Application No: AW/3/21/HH
Site Address: 4 Shorecroft Aldwick PO21 4AS
Description of works: Single storey rear extension and loft conversion with enlarged rear dormer window and two modest front facing dormer windows. Alterations to fenestration, Canopy to side elevation, Planter and replacement handrail to roof terrace.

Thank you for your internet representation made on 3rd February 2021 which has been recorded as an objection with the comments as follows:

Drawing No. Date:
C.1062H - 04 22-12-20

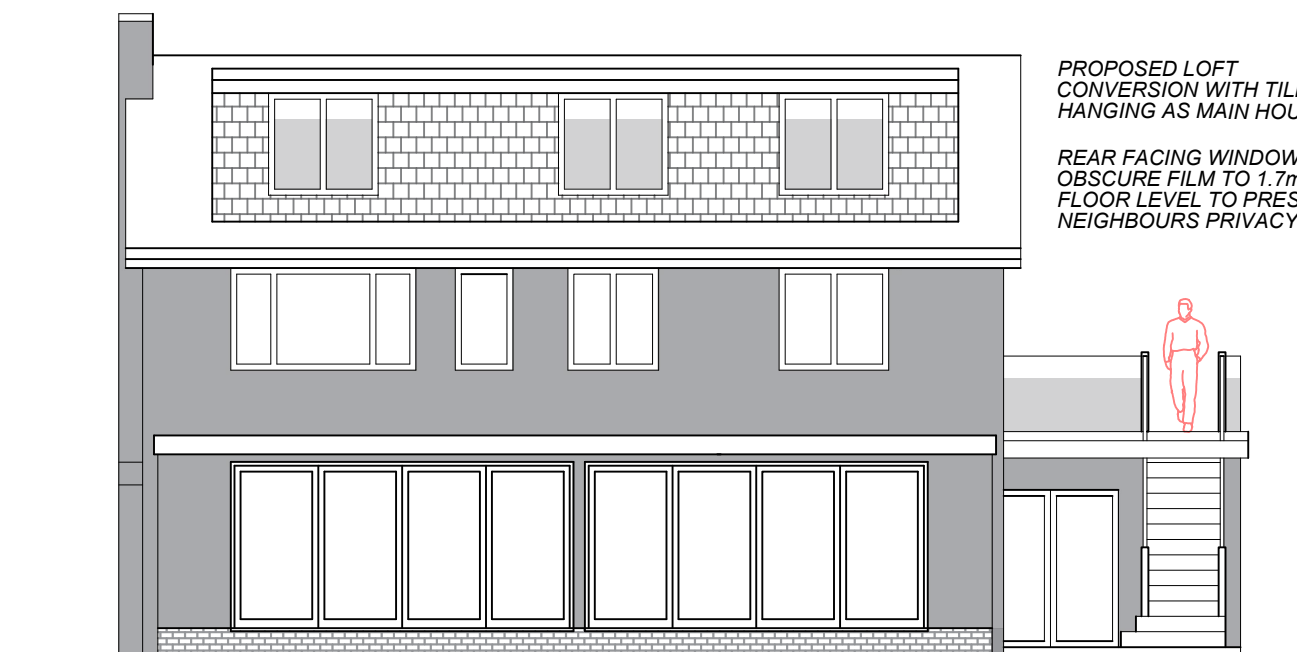
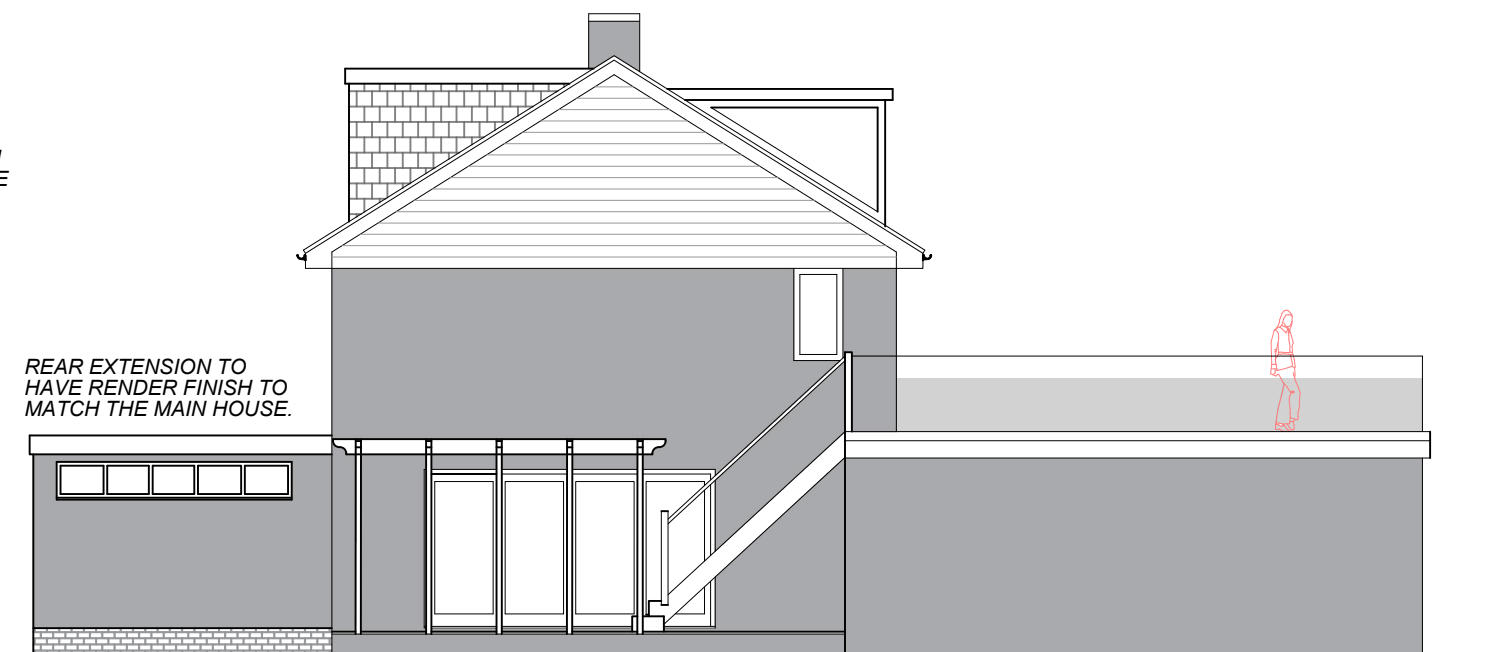
I object on the grounds that the proposed rear dormer window would result in a total lack of privacy of my bungalow and garden. The proposed rear dormer is completely out of keeping with all of the properties in the surrounding roads making it a three storey property on an estate that is predominantly made up of single storey bungalows.

I am unable to see how any screening would be possible to allow any privacy to the bungalows at the rear of the proposed extension and would leave the three properties without privacy and dominated by an overbearing three storey property.
